**Application by Smart Wind Ltd
Hornsea Offshore Wind Farm (Zone 4) – Project 2**

Planning Inspectorate Reference: EN010053

**Environment Agency's summary of Relevant
Representations made on 22 April 2015**

Figure 4.1 Waste Hierarchy

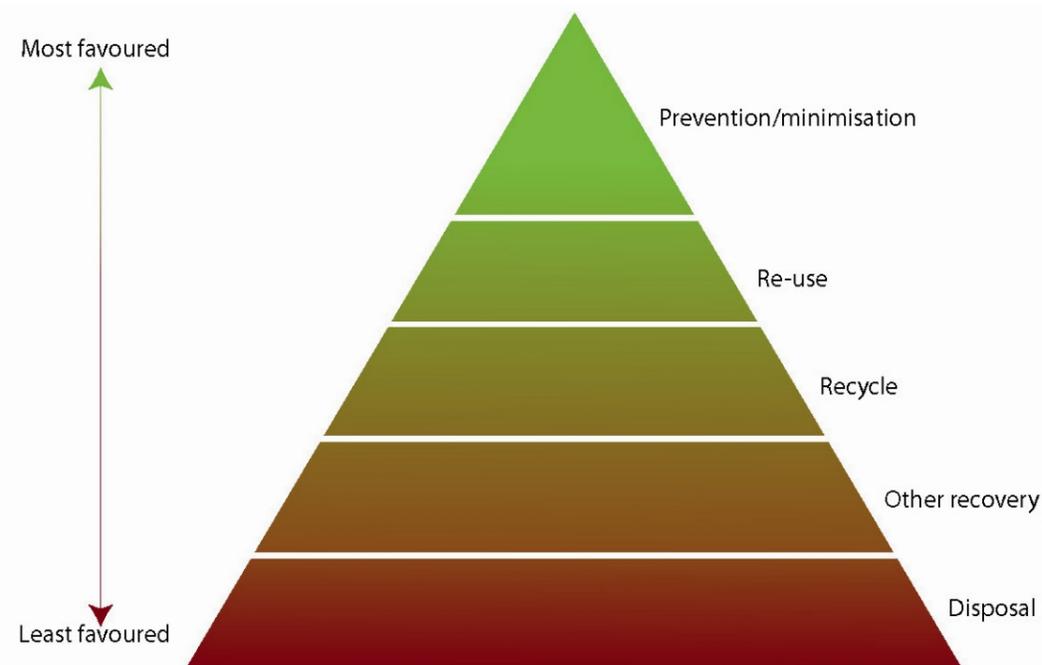
The European Waste catalogue code for drilling muds is incorrect.
